3/2021/0139

Application for a non-material amendment following a grant of planning permission.
Town and Country Planning Act 1990

INSTALLATION OF A REPLACEMENT AIR PURIFICATION SYSTEM (VOXIDISER) ADJACENT TO ANOTHER EXISTING VOXIDISER.

REF - 8
 Non-material amendment
 Scale 1 : 560

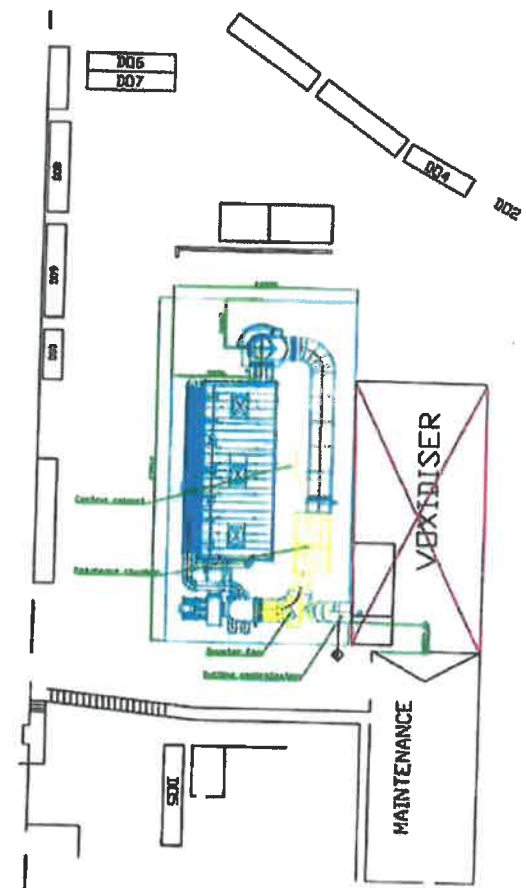
IT CAN BE SEEN IN THE ATTACHED DRAWING THAT THE NON-MATERIAL AMENDMENT WE ARE SEEKING TO MAKE ARE THE FOLLOWING:

- * POSITION OF THE CONTROL CABINET.
- * POSITION OF THE RESONANCE CHAMBER.
- * POSITION OF THE BOOSTER FAN.
- * THE CENTRALISATION OF THE INTERCONNECTING DUCTING.

THE ABOVE AMENDMENT IS REQUESTED IN ORDER TO REDUCE THE MACHINERY FOOTPRINT, IMPROVE THE SAFETY WHEN MAINTAINING THE UNIT & REDUCE THE AMOUNT OF CONCRETE REQUIRED ON INSTALLATION.
